# Sea Link

Document 7.4.10: Statement of Common Ground Between National Grid Electricity Transmission and the Maritime and Coastguard Agency.

Planning Inspectorate Reference: EN020026

Version: E  
April 2026

Plate 1.1 Cable route overview showing stakeholder areas of concern in relation to water depth

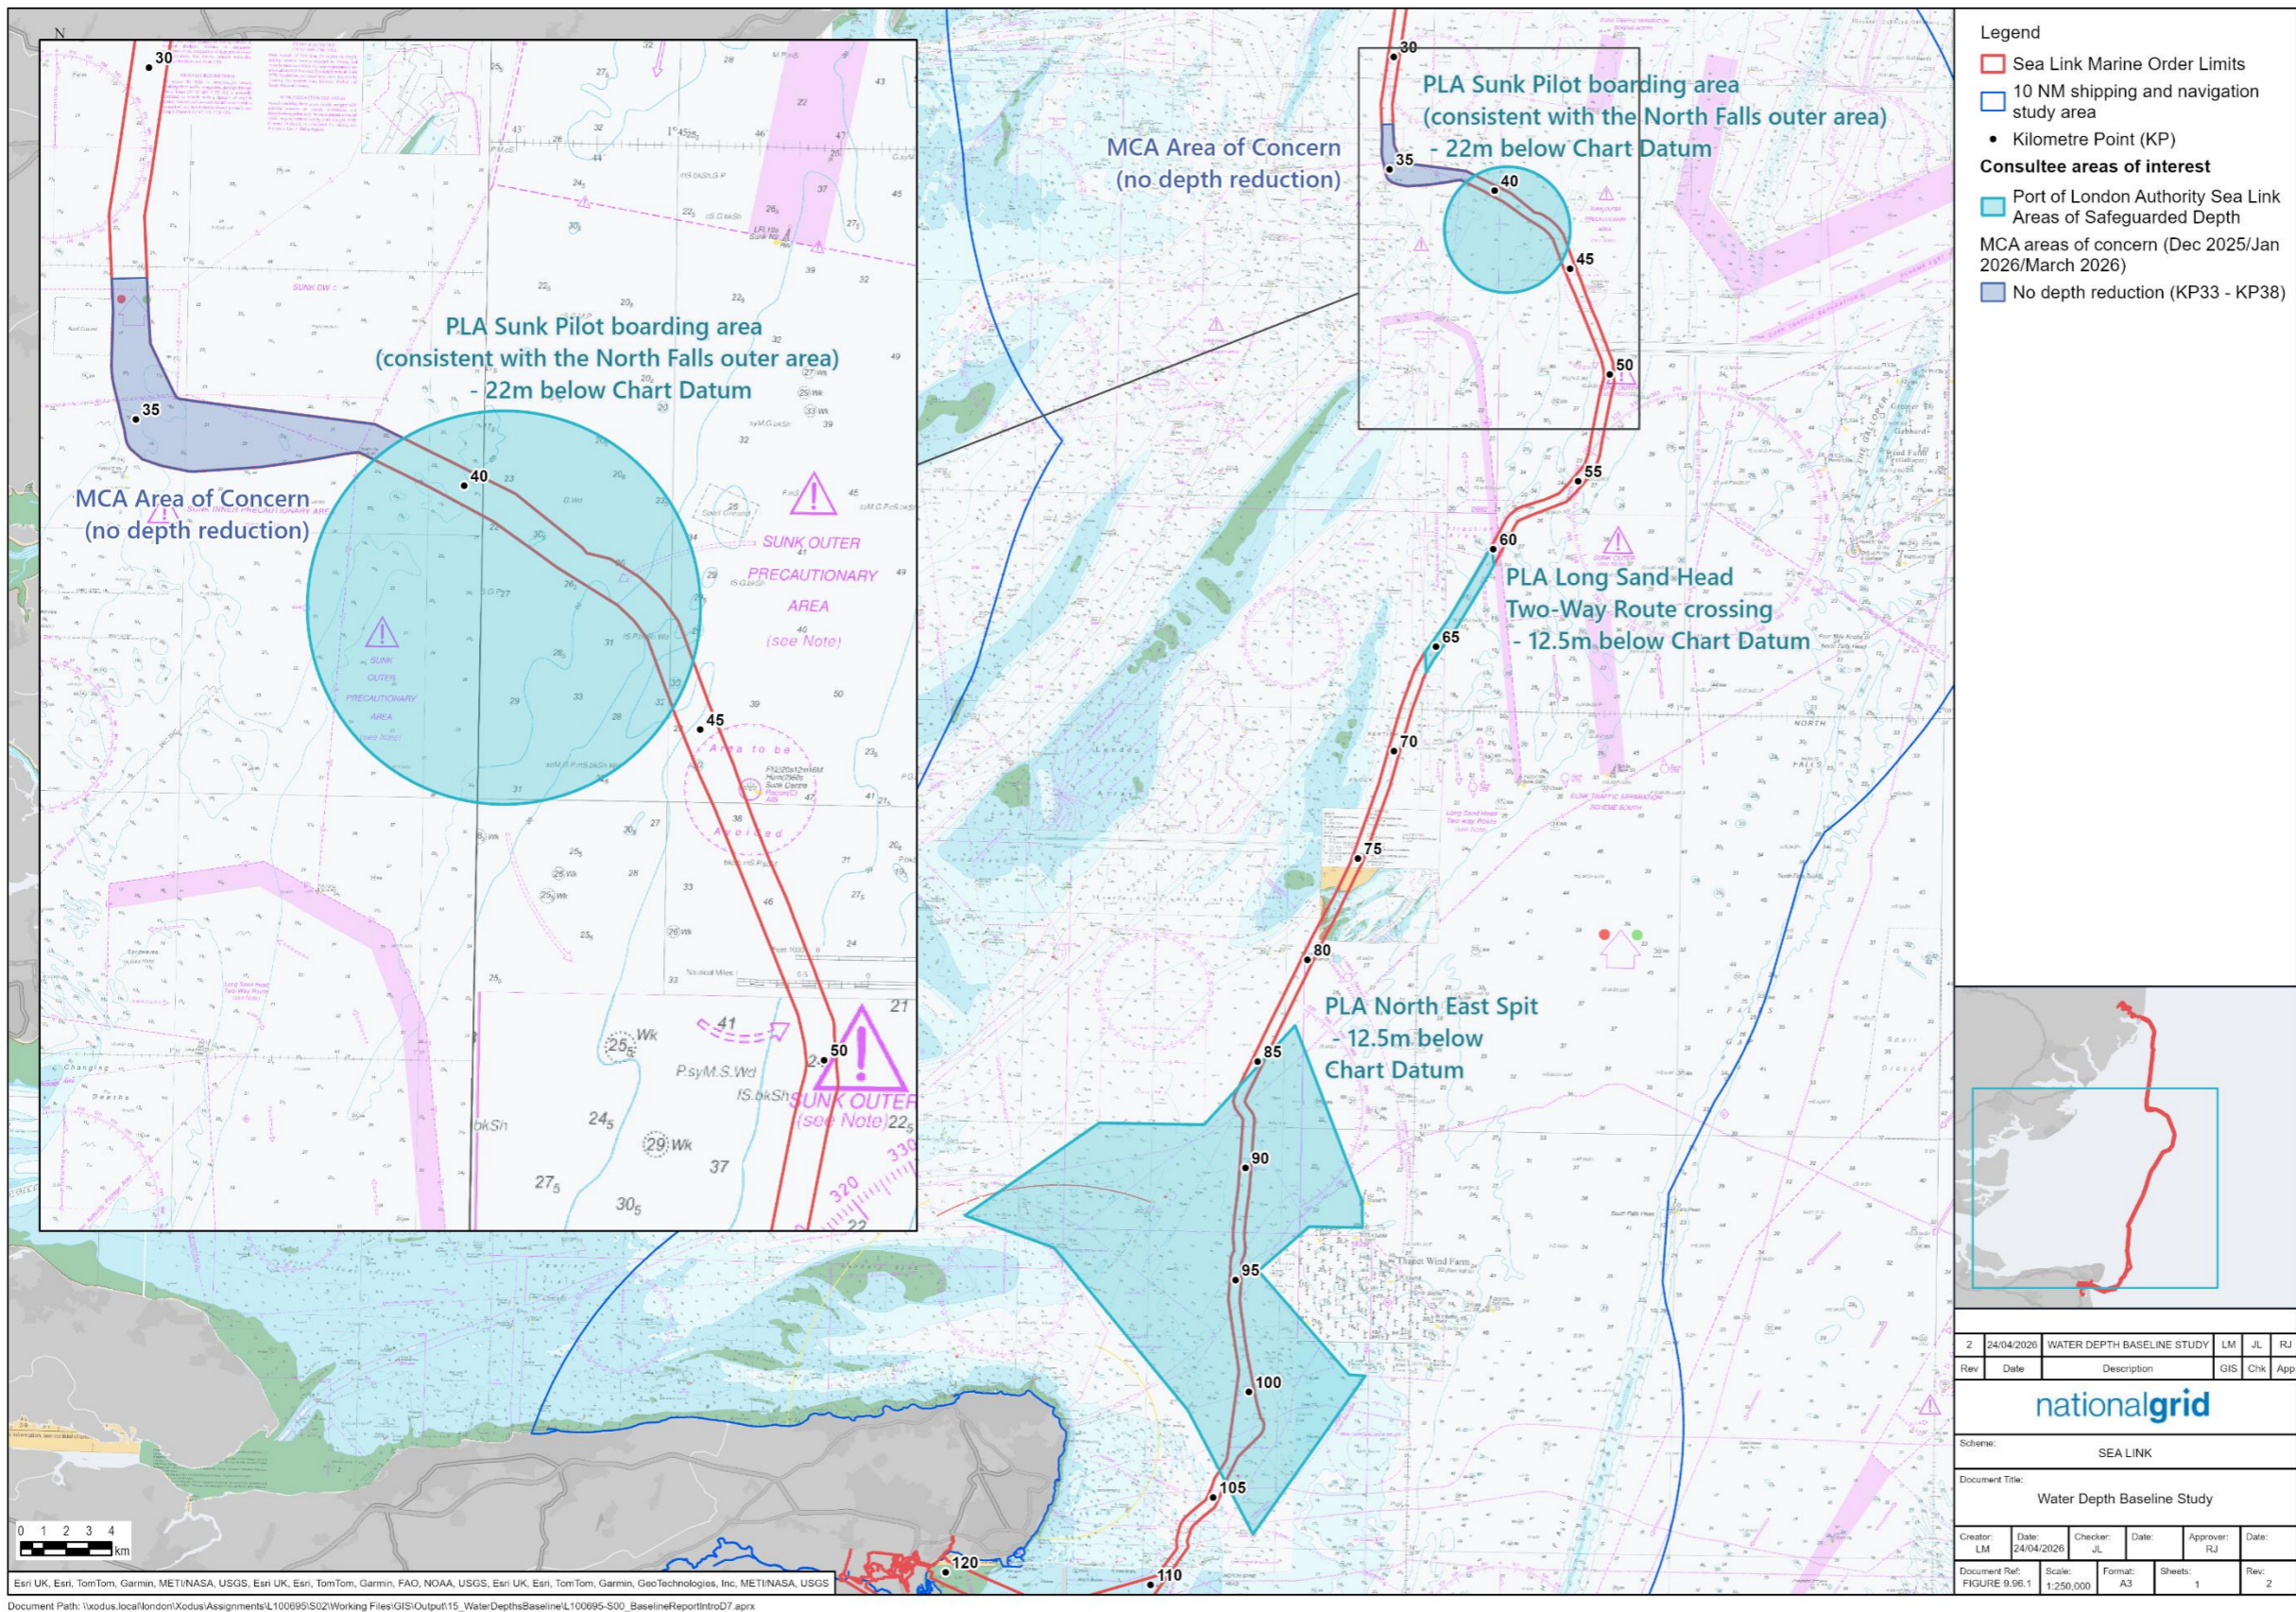
The MCA has clarified this to the project team on 2<sup>nd</sup> March that at KP 33-38 there should be no depth reduction as per CBRA due to the proximity of the Deep Water anchorage, and at KP38-KP44 the ports' 22m requirement applies. The 5% applies to the whole cable route outside of any agreed safe guarded depths, whichever provides maximum depth. There is no conflict therefore with the port's requirements.

Additionally, the Consultee has clarified that their position is that there should be no depth reduction between KP33-38. The Applicant has secured this in the DCO dML part 2 Schedule 16. Please see reference 3.2.9 for further detail on this commitment. Further to the above, the Applicant confirms that an update to **Application Document 9.12 (B) Outline Navigation and Installation Plan was submitted at Deadline 4 [REP4-076]** in consideration of the MCA's feedback was undertaken and is secured within the deemed Marine Licence (dML) under Condition 4.

Long Sand Head Two-Way Route region (KP 45-85). The Applicant confirms that this is currently secured as Condition 4(6) within the deemed Marine Licence and is applicable to the whole Offshore Scheme and not just the Areas of Interest identified by the MCA.

Plate 3.1 Cable route overview showing key infrastructure, cable crossings, water depths, and vessel density

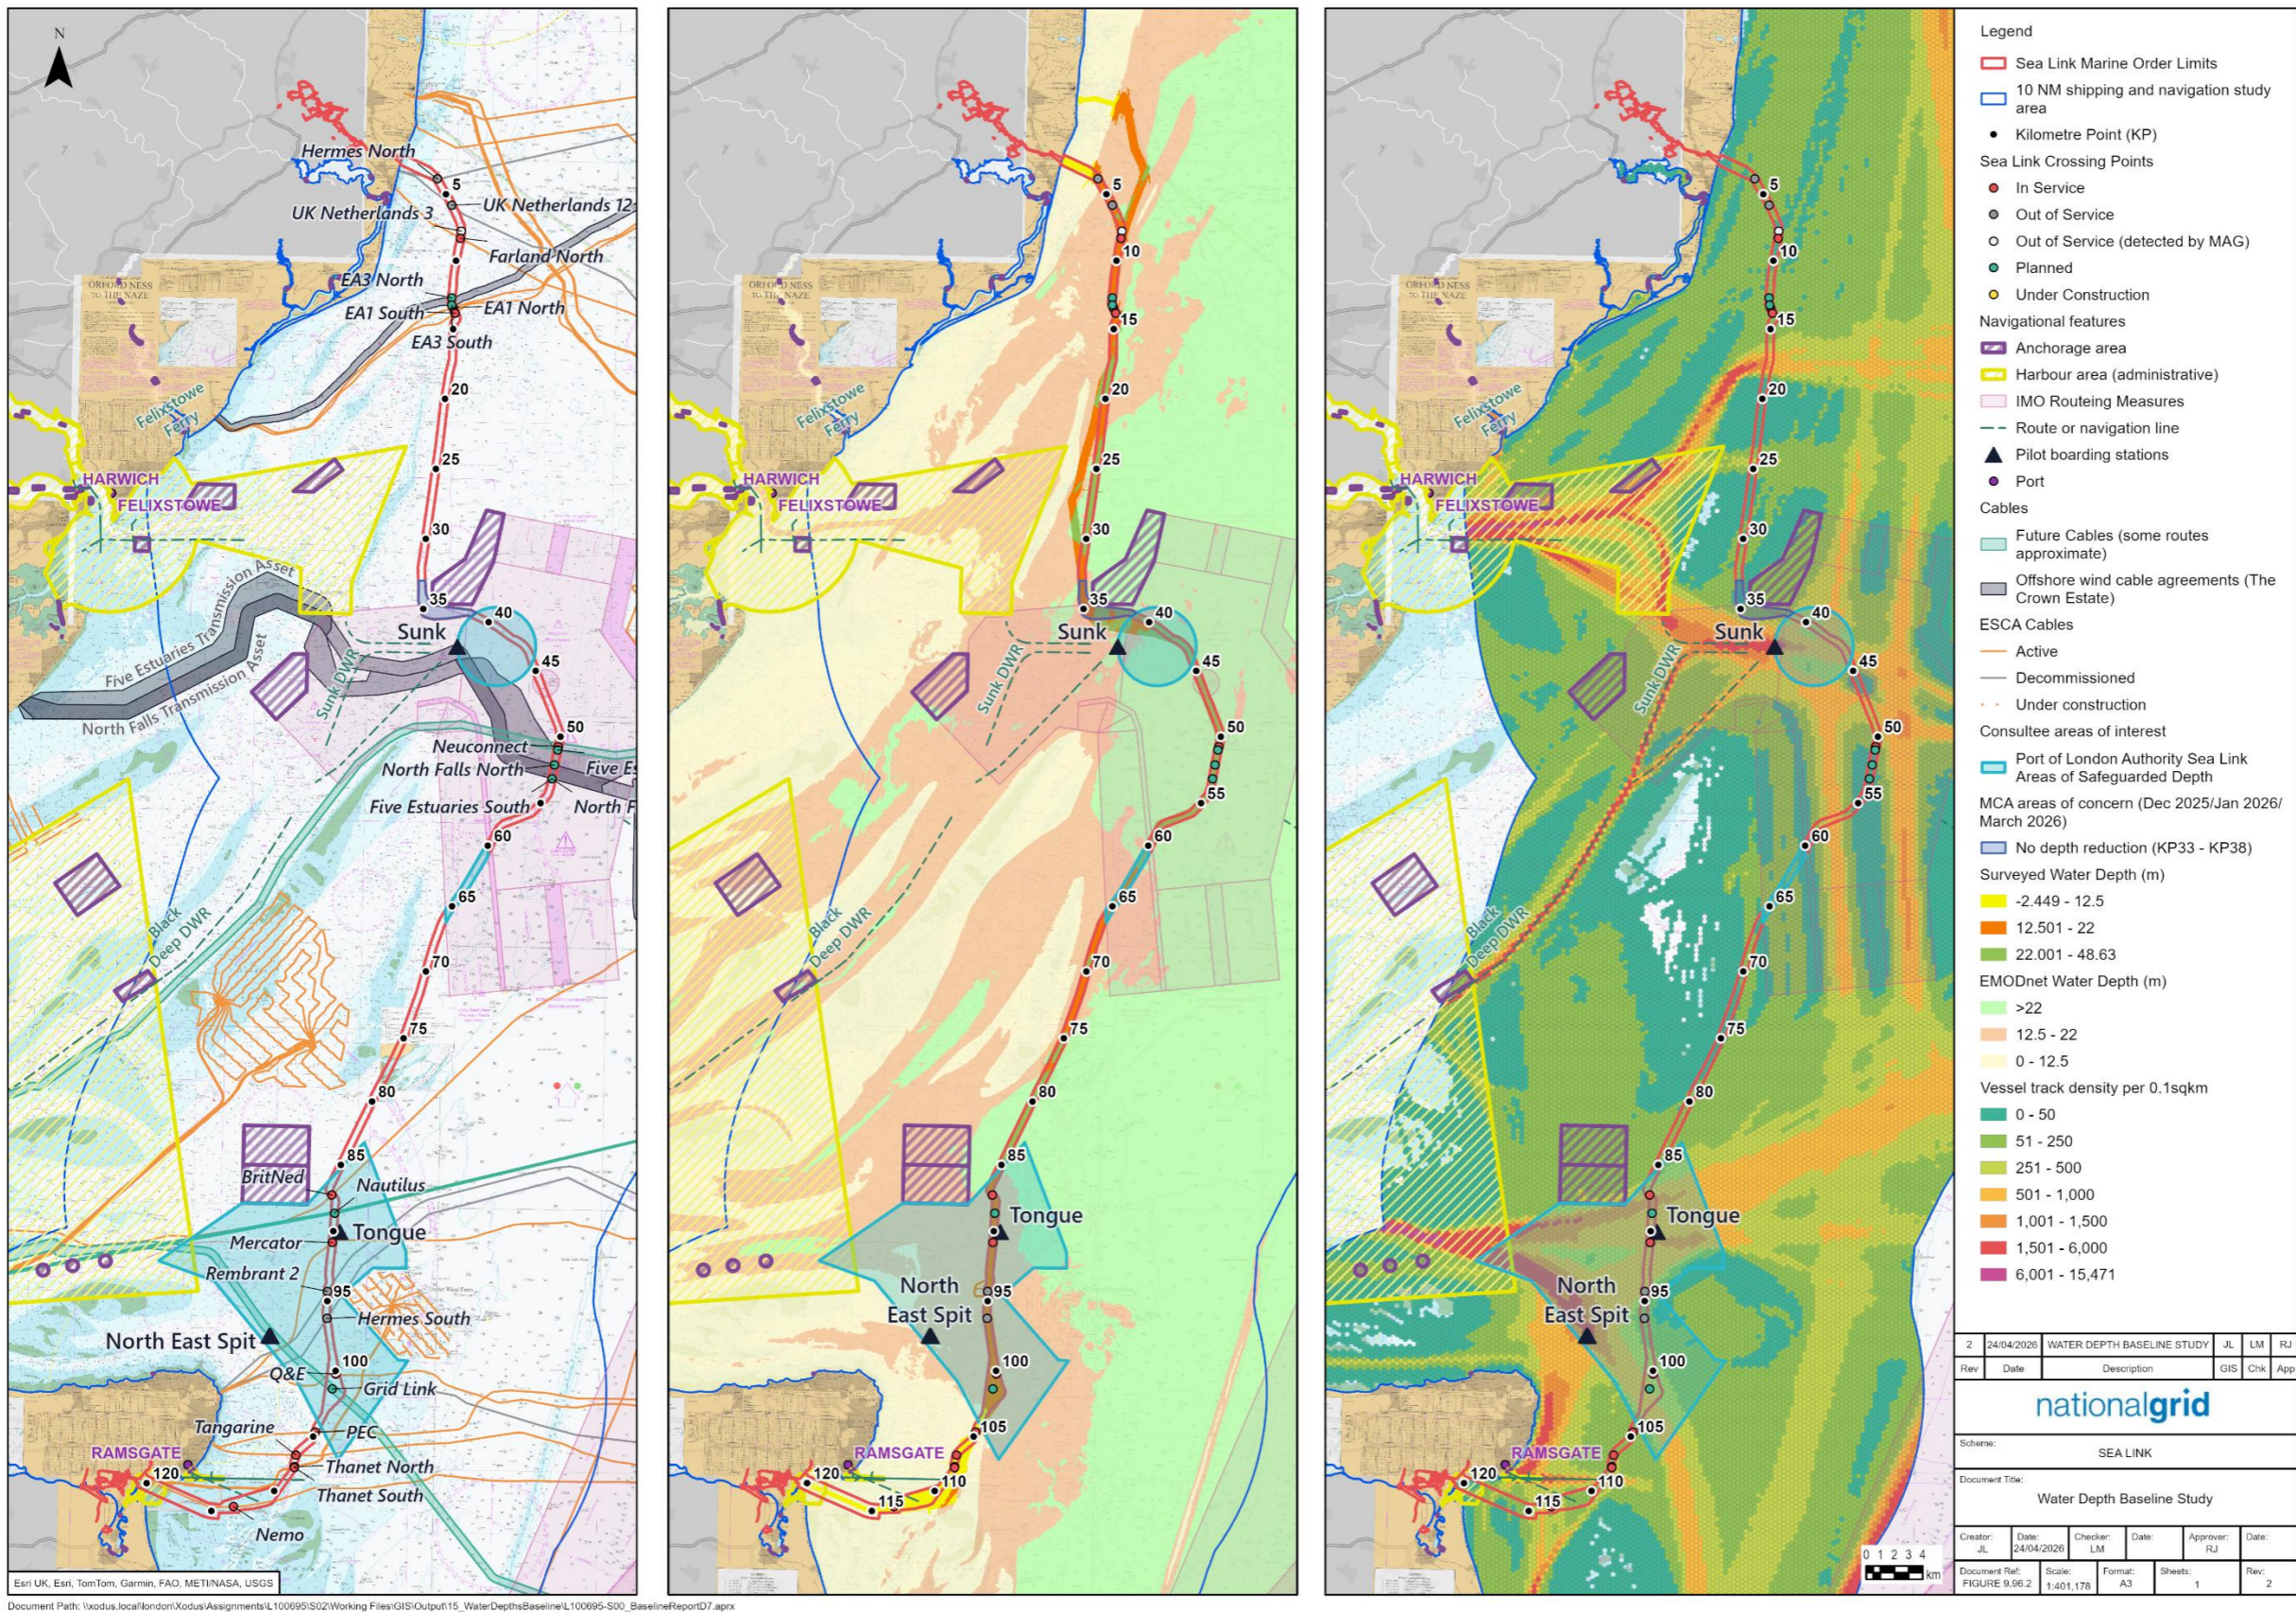
3.2.8	<b>Application Document 9.12 (B) Outline Navigation and Installation Plan [REP4-076]</b>	New MCA Areas of Interest, Dec 2025	<p>The Consultee has provided the applicant with MCA's area of interest (AOI) for safeguarded 22m water depth, and the AOI for concurrent RAM and Restricted Visibility Stop Ops.</p> <p>The MCA's position remains as per written response and as presented at the meeting on 16 January 2026. No activities involving vessels Restricted in Ability to Manoeuvre (RAM) should run concurrently with activities involving RAM vessels planned by the Five Estuaries and North Falls project developers from KP 33 – KP 50 (as per box on image below). And no project vessels with Restricted Ability to Manoeuvre (RAM) (cable laying, UXO clearance, survey etc) are to operate in the wider Sunk area when visibility is below nautical 2 miles.</p>	<p>The Consultee sent the Applicant four additional areas of interest in December 2025. The Applicant sought further clarity from the MCA on these new areas, which were substantially larger and more restrictive in their requirements than those which the Applicant and ports stakeholders have been collaborating on, and on which the Applicant and ports stakeholders have previously reached agreement. The Applicant discussed this matter at a meeting with the MCA arranged on 16 January 2026.</p> <p>The Applicant confirms that following the meeting on the 16 January 2026, clarity was provided from the MCA with regards to their Areas of Interest, as detailed below.</p> <p><u>Safeguarding depths</u></p> <p>The Consultee clarified that their position is that they would like the 5% maximum depth reduction to apply outside of the port's 22 m safeguarded depth at the Sunk, and across the</p>

On the understanding that this is included in the updated NIP, and in accordance with plate 3.1, the MCA would be content. The MCA do not currently have the D7 updated NIP to confirm this but trust it will be included with clarity on the MCA defined areas for simultaneous RAM operations and during restricted visibility.

The Proposed Project's Outline Navigation and Installation Plan contains a figure which shows the Sea Link "Sunk Pilotage Concurrent RAM Activity Area" (Plate 3.1) which has been agreed with Port of London Authority (PLA) Harwich Haven (HHA) and the Sunk VTS / Maritime Coastguard Agency (MCA), Trinity House, Five Estuaries and North Falls during a face to face workshop led by Five Estuaries on 14 June 2024.
